KITTITAS COUNTY DEPARTMENT OF PUBLIC WORKS

MEMORANDUM

TO: Jeff Watson, Community Development Services
FROM: Christina Wollman, Planner II *CW*
DATE: August 5, 2010
SUBJECT: Cle Elum Ridge SG-10-00012

Our department has reviewed the Request for Parcel Segregation Application and finds that it meets current Kittitas County Road Standards.

RECORD OF SURVEY PREPARED FOR CLE ELUM RIDGE LOT 6A LLC A PORTION OF SECTION 23, TOWNSHIP 20 NORTH, RANGE 15 EAST, W.M. KITITAS COUNTY WASHINGTON		
DWN BY G. WEISER	DATE 05/2010	JOB NO. 10039
CHKD BY D. NELSON	SCALE 1"=200'	SHEET 1 OF 1

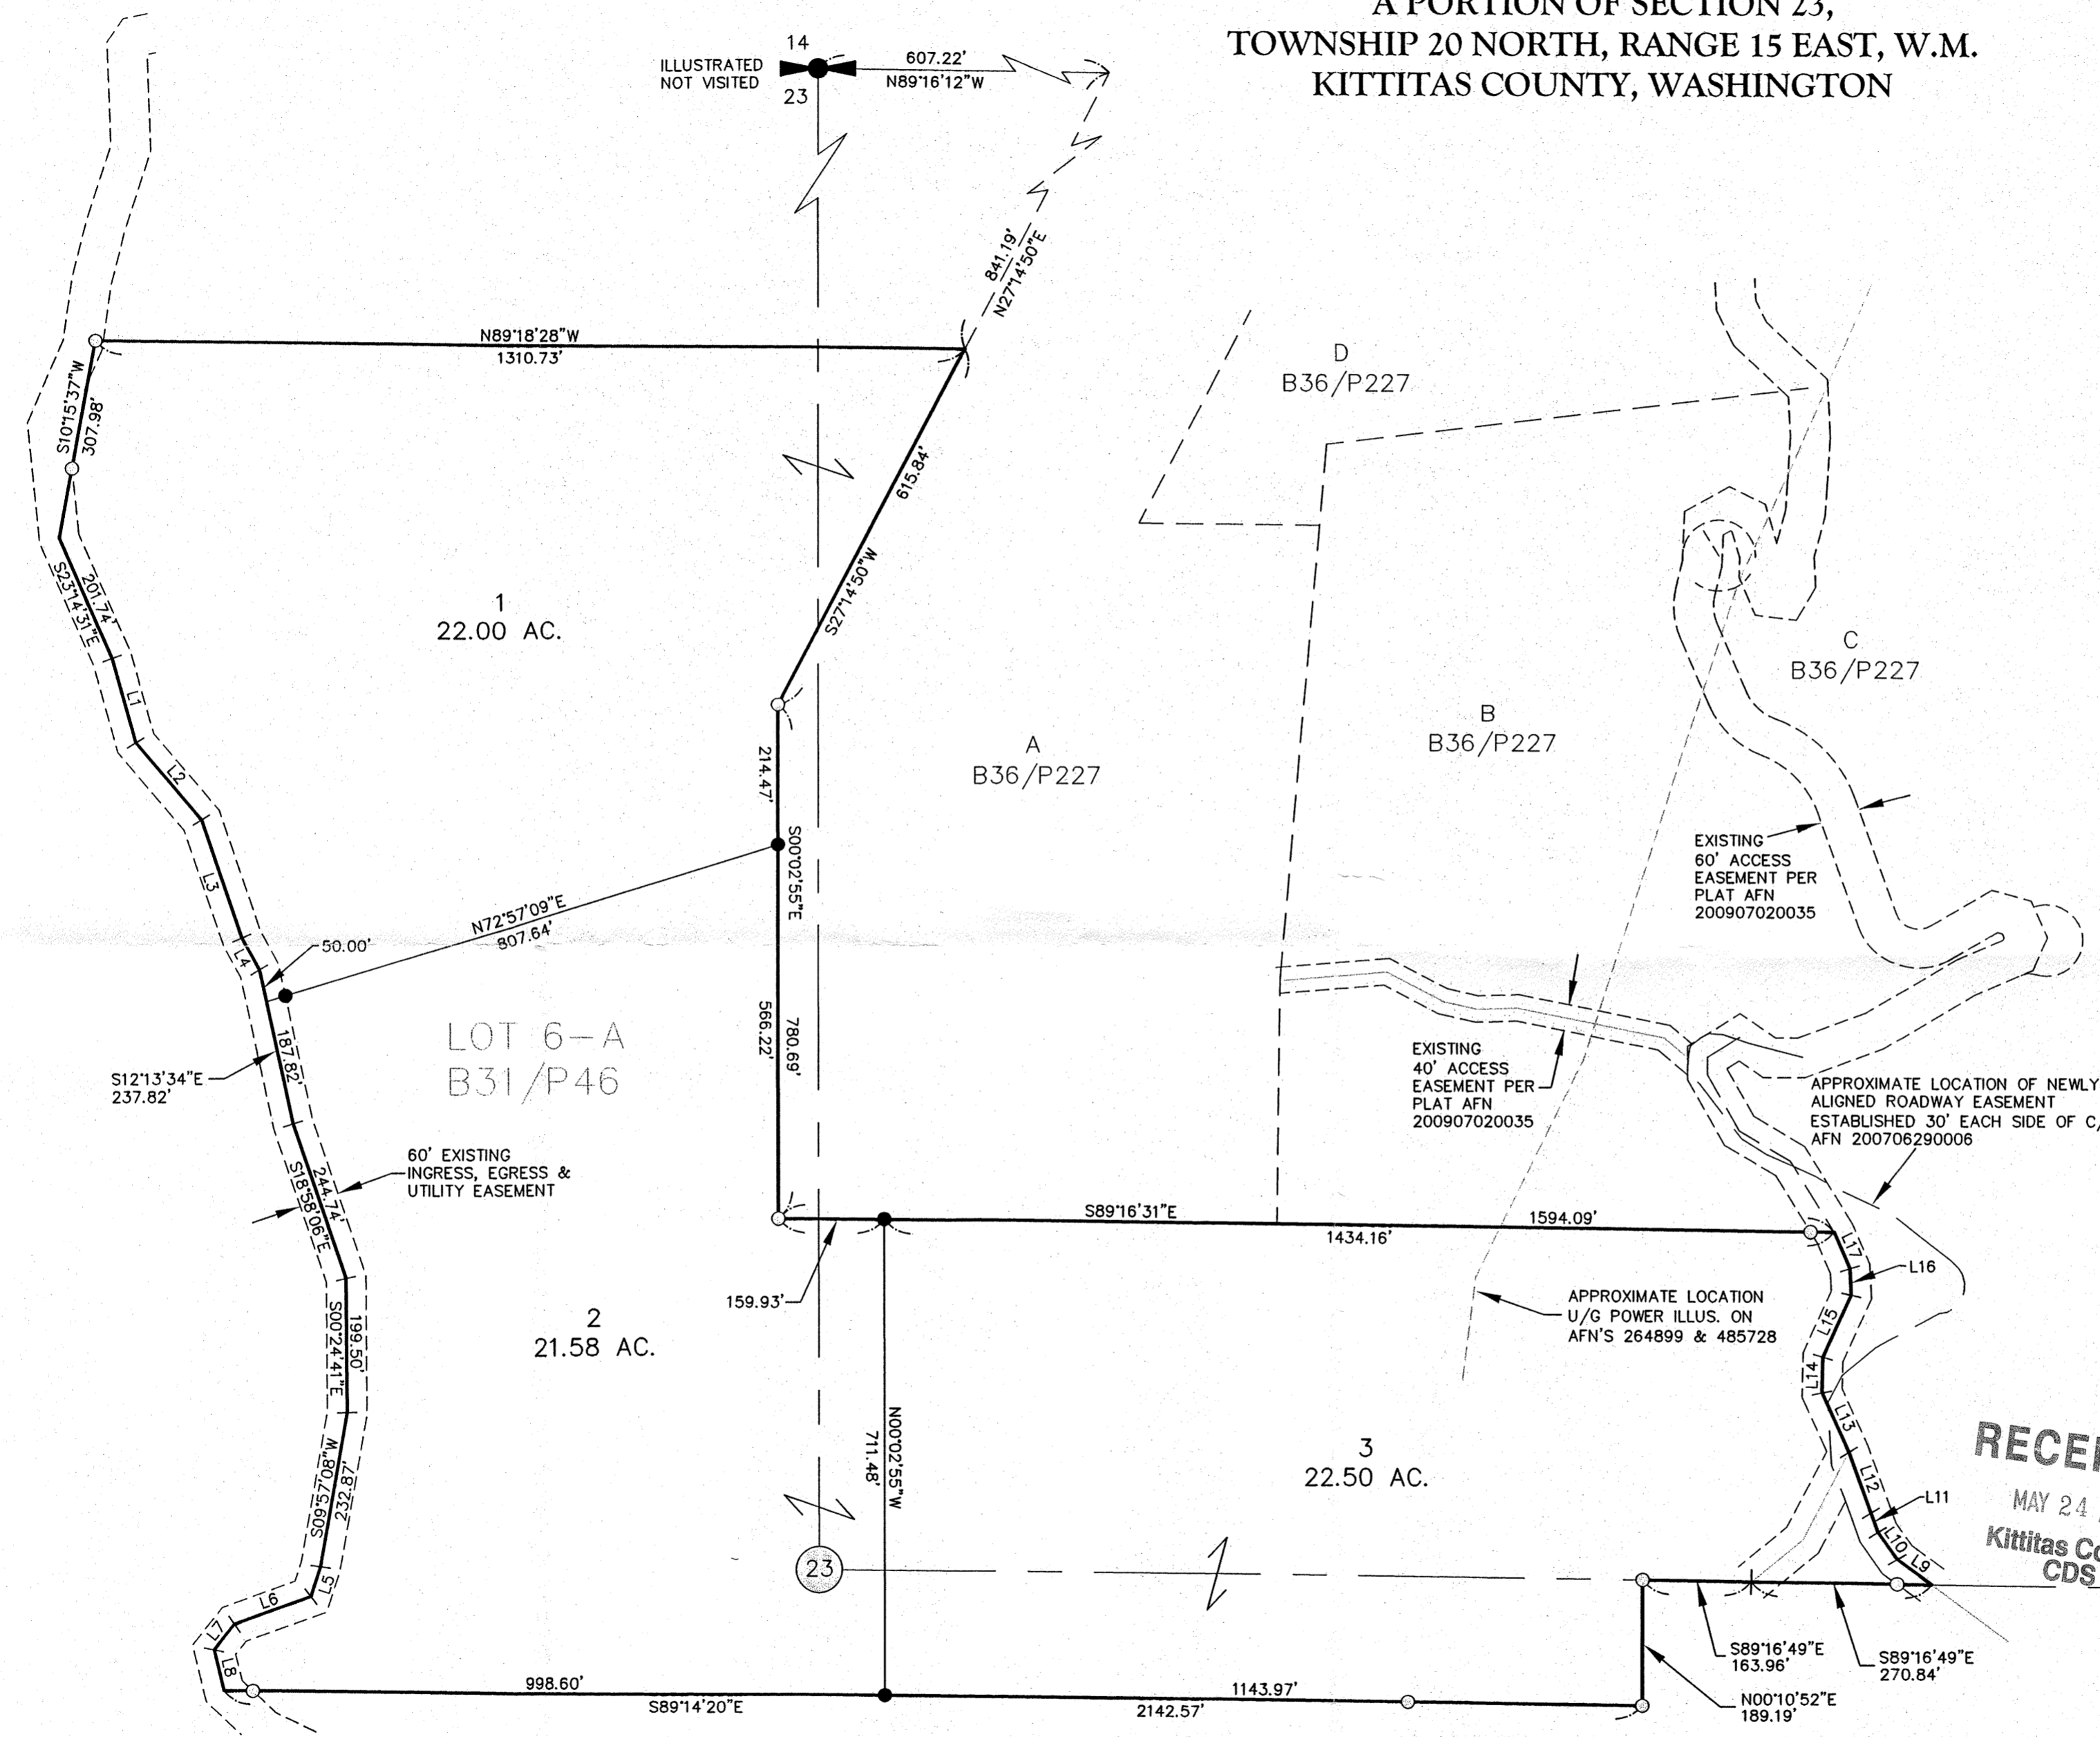
2. Private Road Improvements: Summit View Road, Big Tail Road and the un-named center road shall be constructed as a Low-Density Private Road. See Kittitas County Road Standards, 9/6/05 edition.

- a. Access easements shall be a minimum of 60' wide. The roadway shall have a minimum width of 20', with 1' shoulders, for a total width of 22'.
 - b. Minimum centerline radius will be 60'.

- c. The surface requirement is for a minimum gravel surface depth of 6".
 - d. Maximum grade is 12%.
 - e. Stopping site distance, reference AASHTO.
 - f. Entering site distance, reference AASHTO.

- k. A paved apron shall be constructed at the intersection of the proposed private intersection and the county road right of way.
3. Cul-de-Sac: A cul-de-sac turn-around having an outside right-of-way easement diameter of at least 110 feet shall be constructed at the closed end of all dead-end roads serving 3 or more lots. The driving surface shall be at least 96 feet in diameter. Cul-de-sacs must also conform to the requirements specified by the 2006 International Fire Code. Contact the Fire Marshal regarding any additional cul-de-sac requirements.
